CITY OF ALBUQUERQUE

October 12, 2020

**Re: Murphy Express
9700 Montgomery NE
Traffic Circulation Layout
Engineer's Stamp 09-08-2020 (G21-D032)**

SHEET NO.
TCL-2

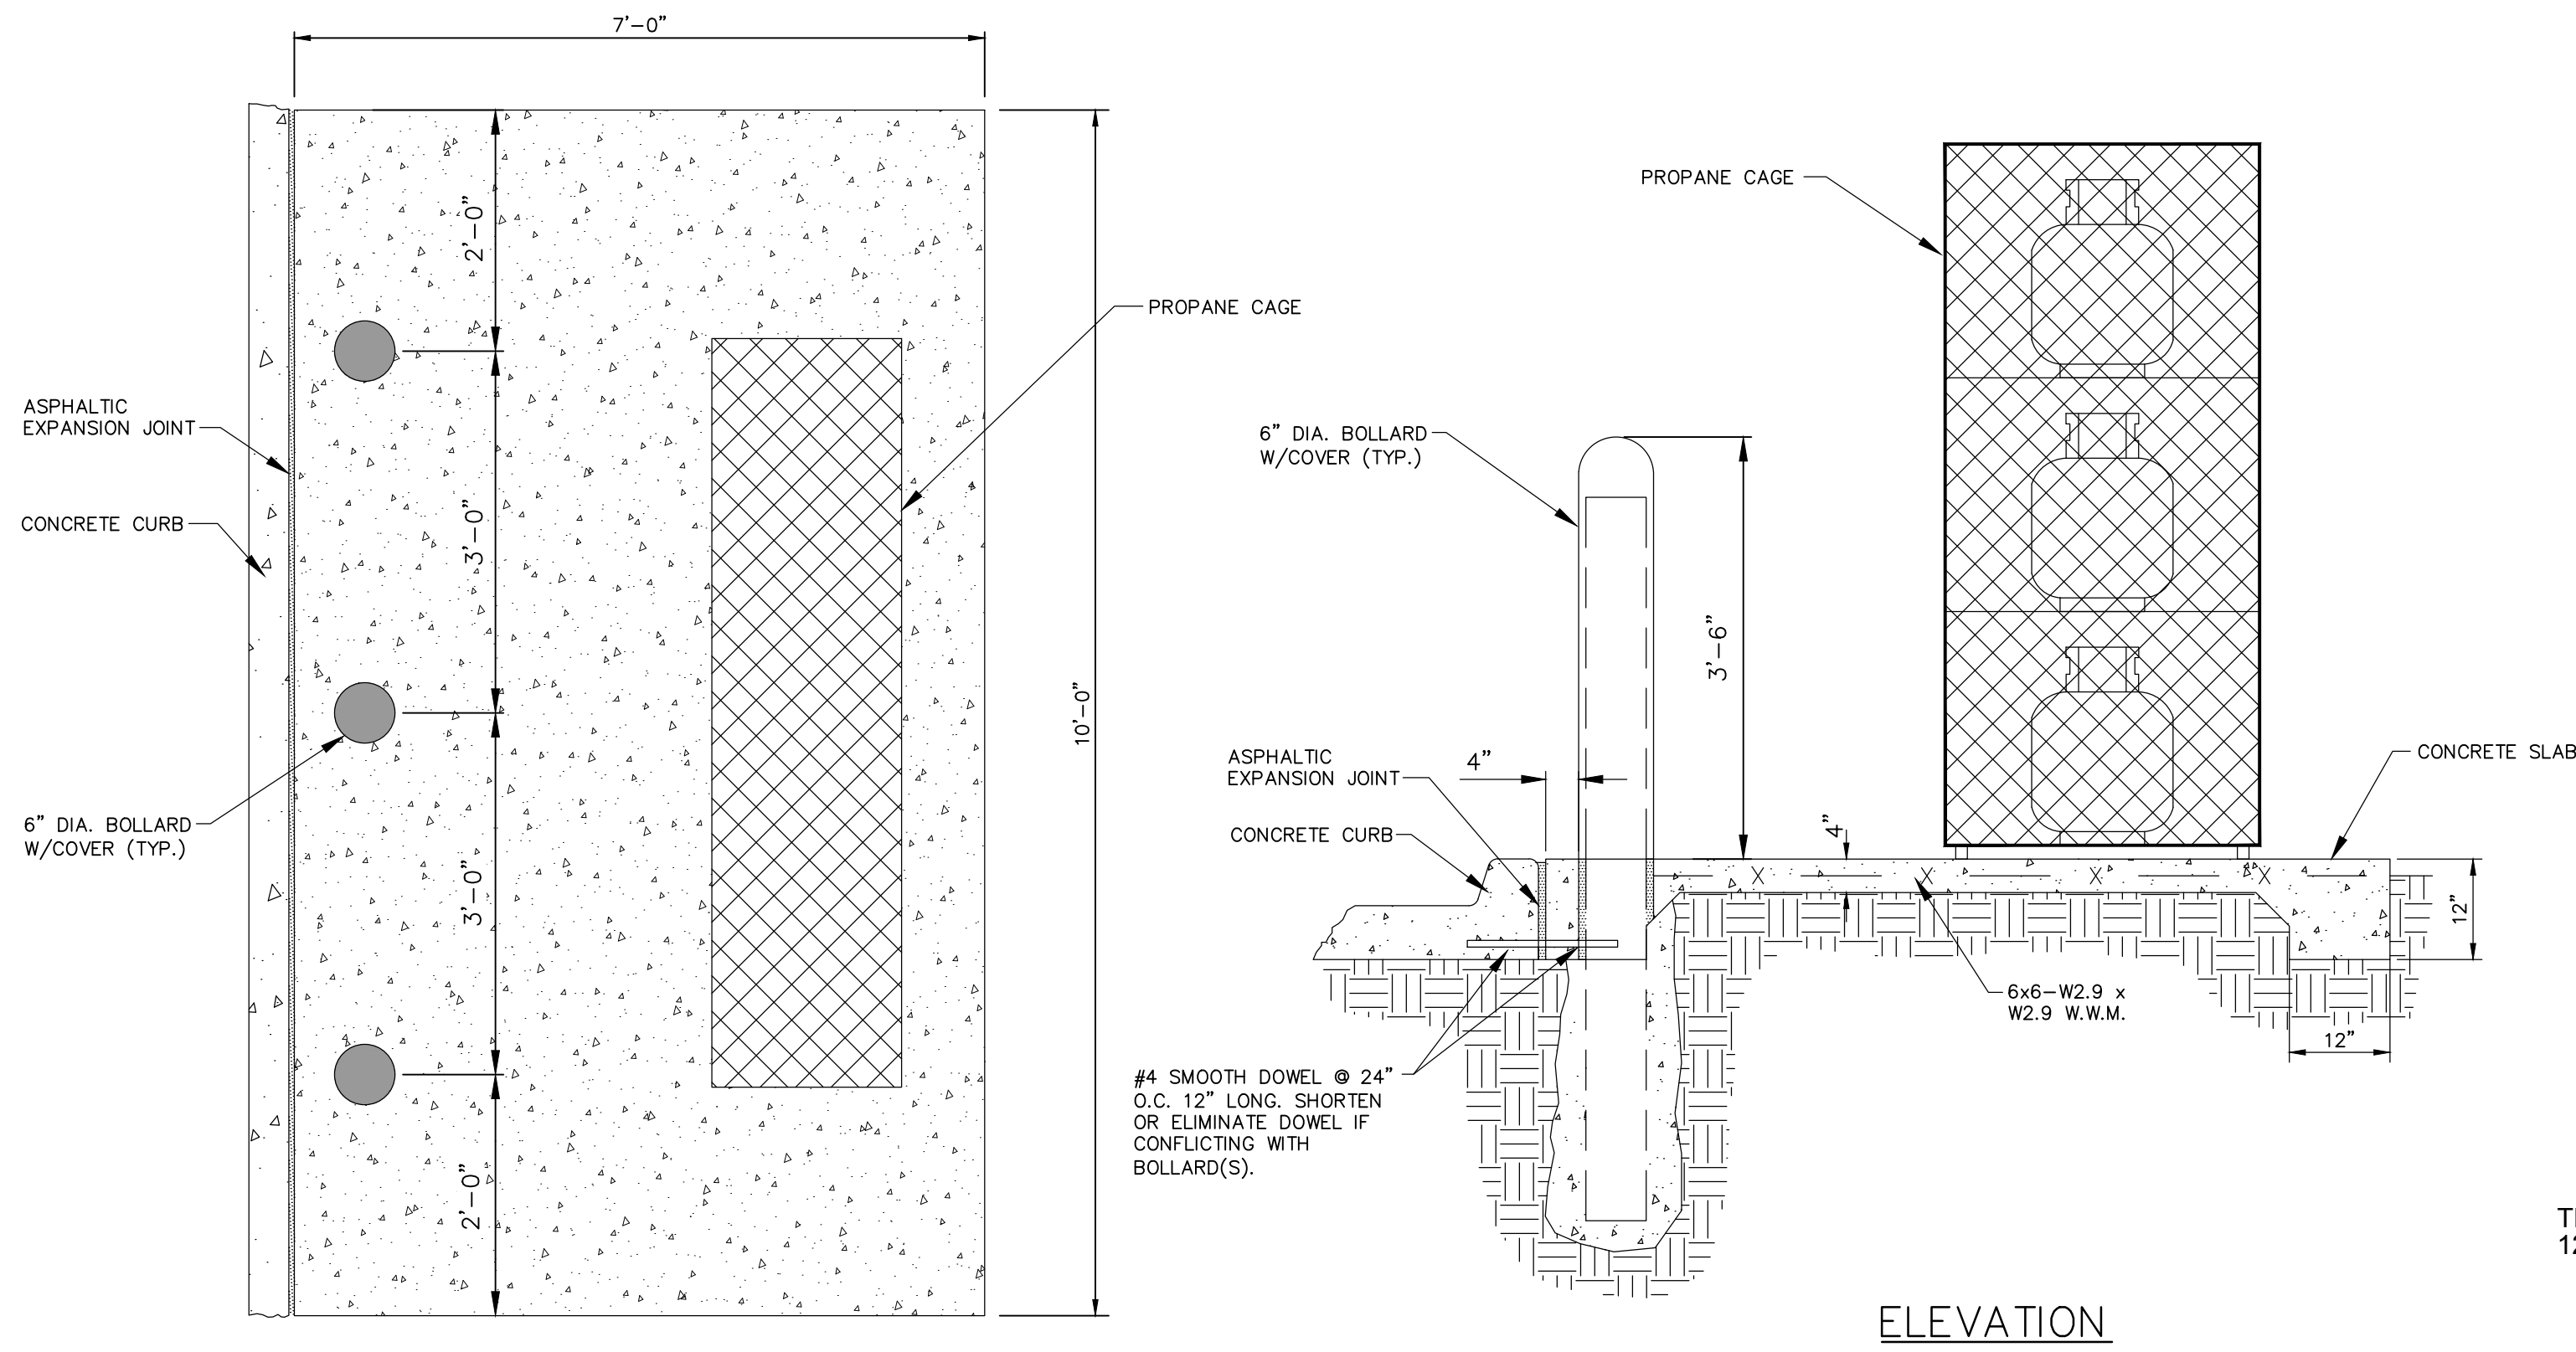
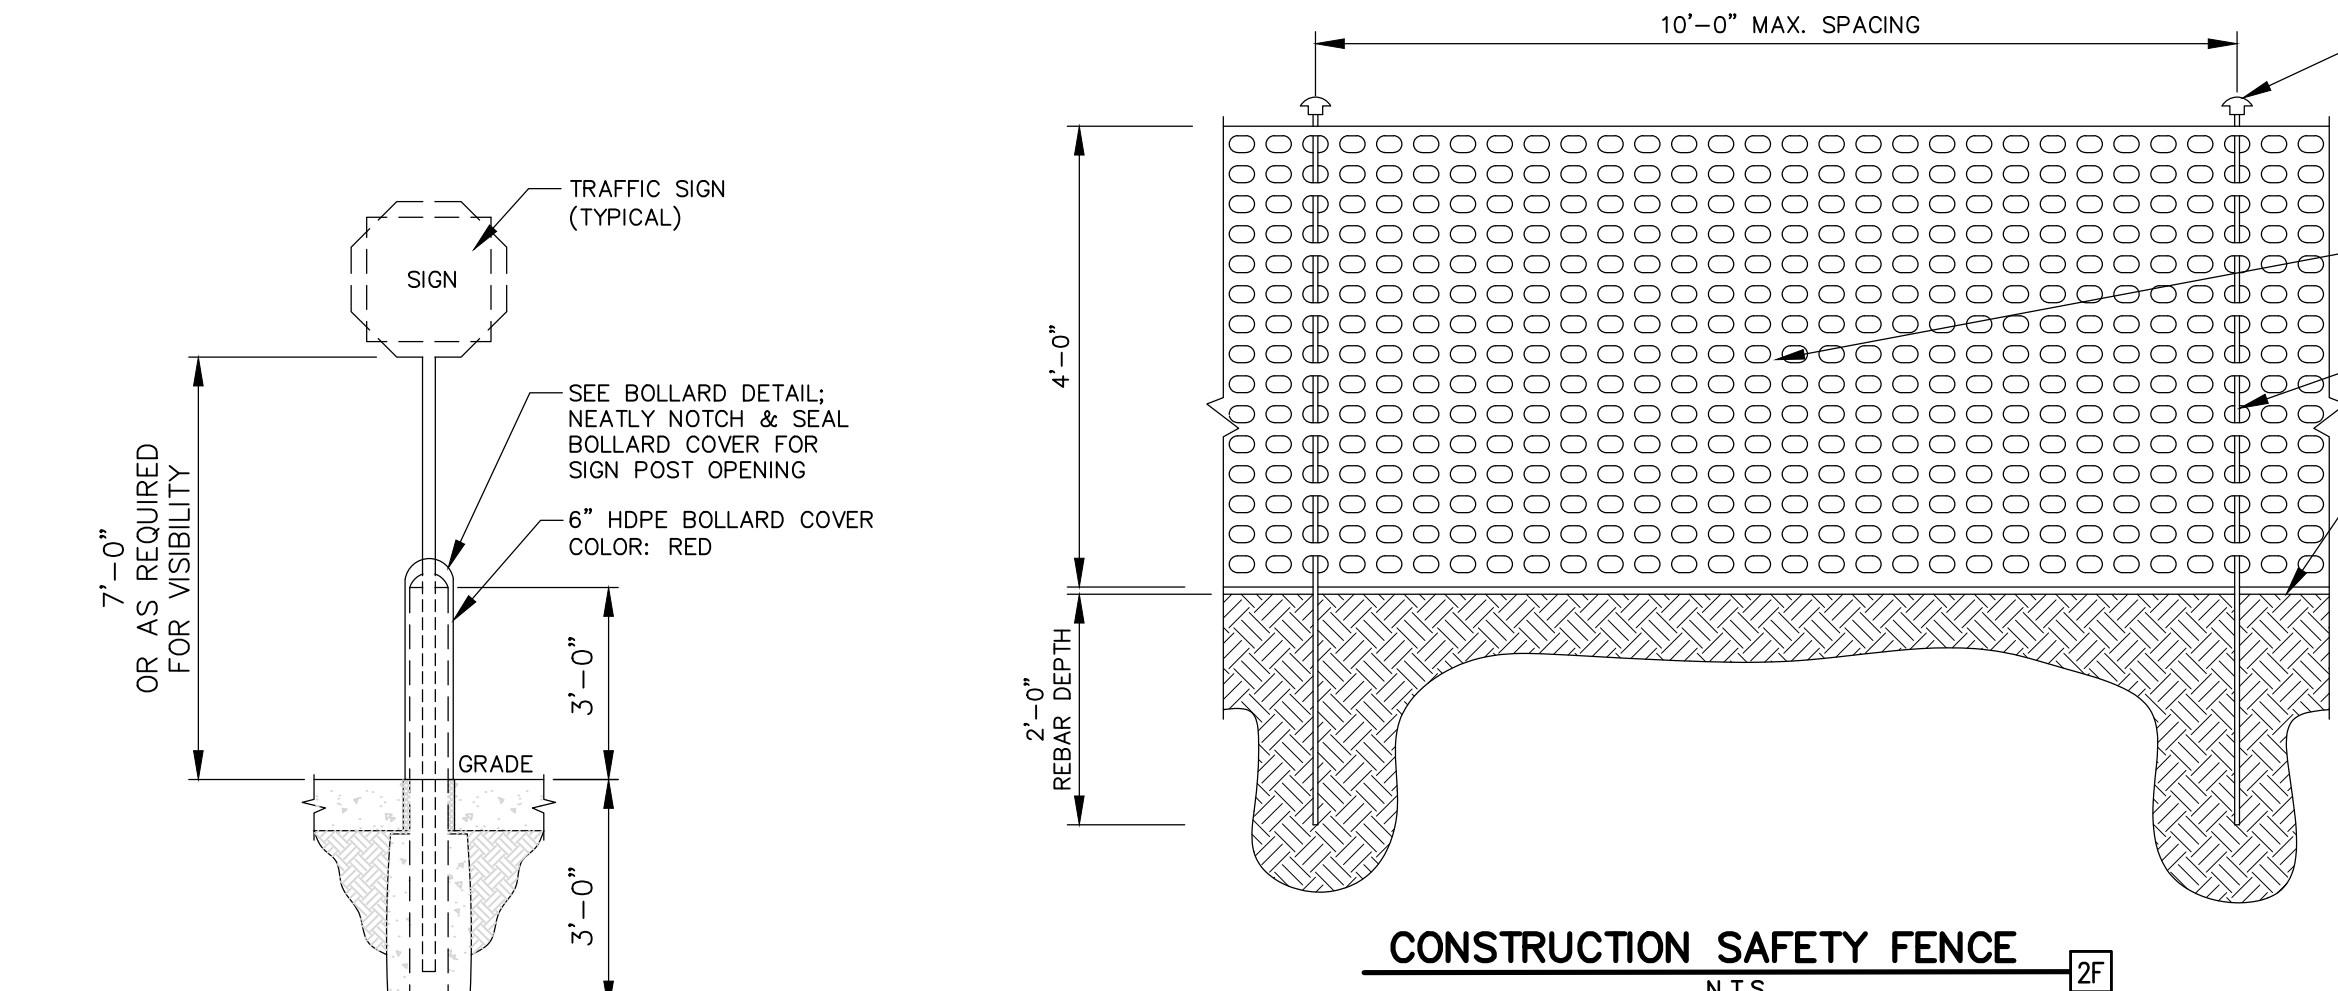
13. **Show all drive aisle widths/lanes (lanes off Montgomery) and radii. Some imensions are not shown.**
14. Per the IDO, **a 6 ft. wide ADA accessible pedestrian pathway** is required from the public sidewalk to the **building entrances**. Please clearly **show this pathway** and provide details.

15. Per DPM, **a 6 ft. wide ADA accessible pedestrian pathway** is required from the ADA parking stall access aisles to the **building entrances**. Please clearly **show this pathway** and provide details.

16. **Provide a copy of refuse approval.**
17. **It is not apparent what type of pavement surface is being proposed. A hard driving surface will be required as part of this proposed project for parking area and drive aisles.**

18. **Please provide a sight distance exhibit**
19. **Show the clear sight triangle and add the following note to the plan:**
"Landscaping and signage will not interfere with clear sight requirements. Therefore, signs, walls, trees, and shrubbery between 3 and 8 feet tall (as measured from the gutter pan) will not be acceptable in the clear sight triangle.

20. **Please specify the City Standard Drawing Number when applicable on any proposed infrastructure not labeled(especially curb & gutter within the parameter of building and infrastructure).**

21. **Shared Site access: driveways that straddle property lines, or are entirely on one property but are to be used by another property, shall have an access easement. Please include a copy of your shared access agreement with the adjacent property owner.**
22. **Add a note stating "All broken or cracked sidewalk must be replaced with sidewalk and curb & gutter." A build note must be provided referring to the appropriate City Standard drawing(2430 & 2415).**
23. **All proposed bollards need to be labeled and paint yellow.**

BIKE RACK [71A]
 N.T.S.

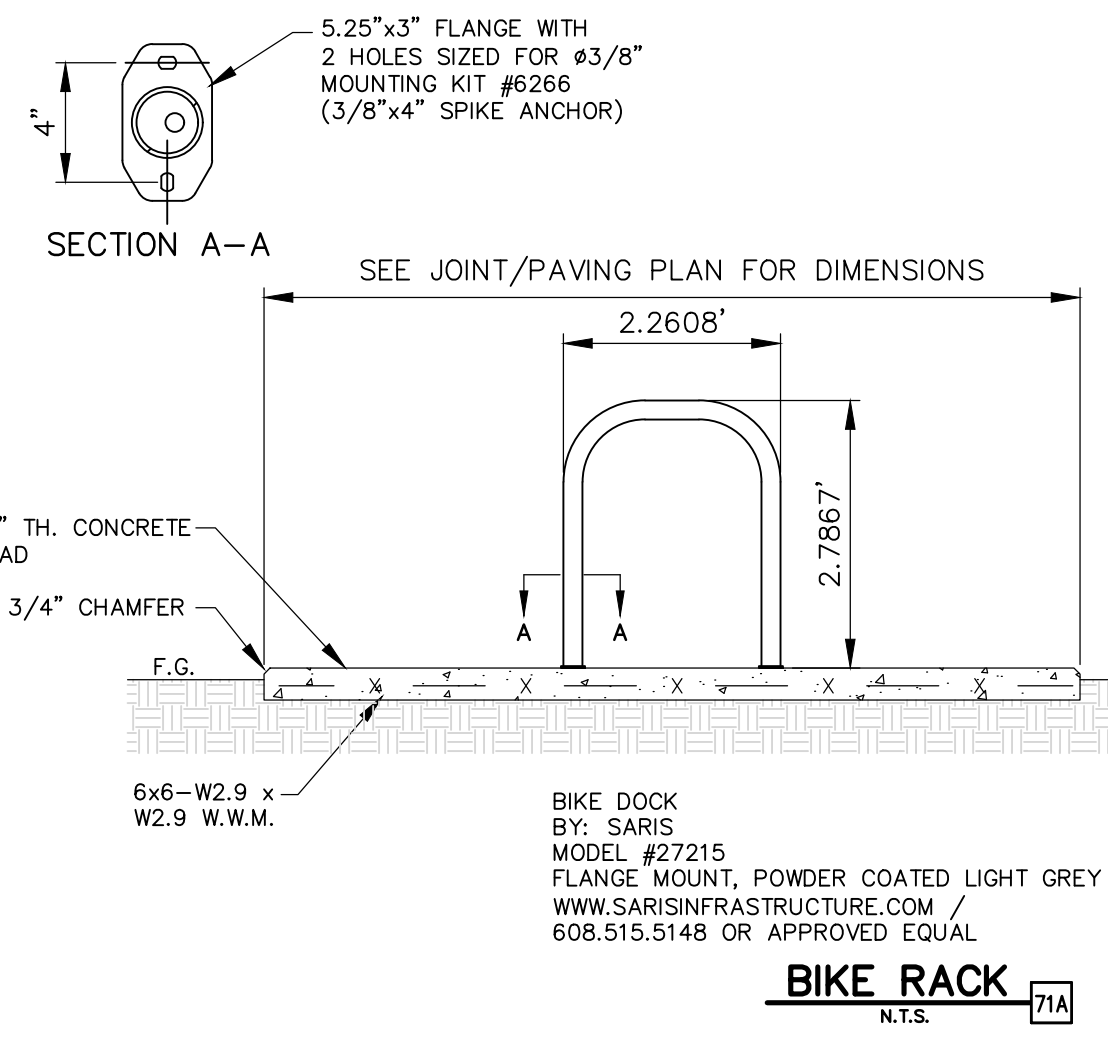
8. Motorcycle parking spaces: Label pavement MC.
9. All bicycle racks shall be designed according to the following guidelines(**IF APPLICABLE NOTES[9-12] FOR THIS PROJECT**):

- a. The rack shall be a minimum 30 inches tall and 18 inches wide.
 - b. The bicycle frame shall be supported horizontally at two or more places. Comb/toaster racks are not allowed.

- c. The rack shall be designed to support the bicycle in an upright position. See the IDO for additional information.
 - d. The rack allows varying bicycle frame sizes and styles to be attached.

- e. The user is not required to lift the bicycle onto the bicycle rack.
 - f. Each bicycle parking space is accessible without moving another bicycle.

10. Bicycle racks shall be sturdy and anchored to a concrete pad.
11. A 1-foot clear zone around the bicycle parking stall shall be provided.
12. Bicycle parking spaces shall be at least 6 feet long and 2 feet wide.
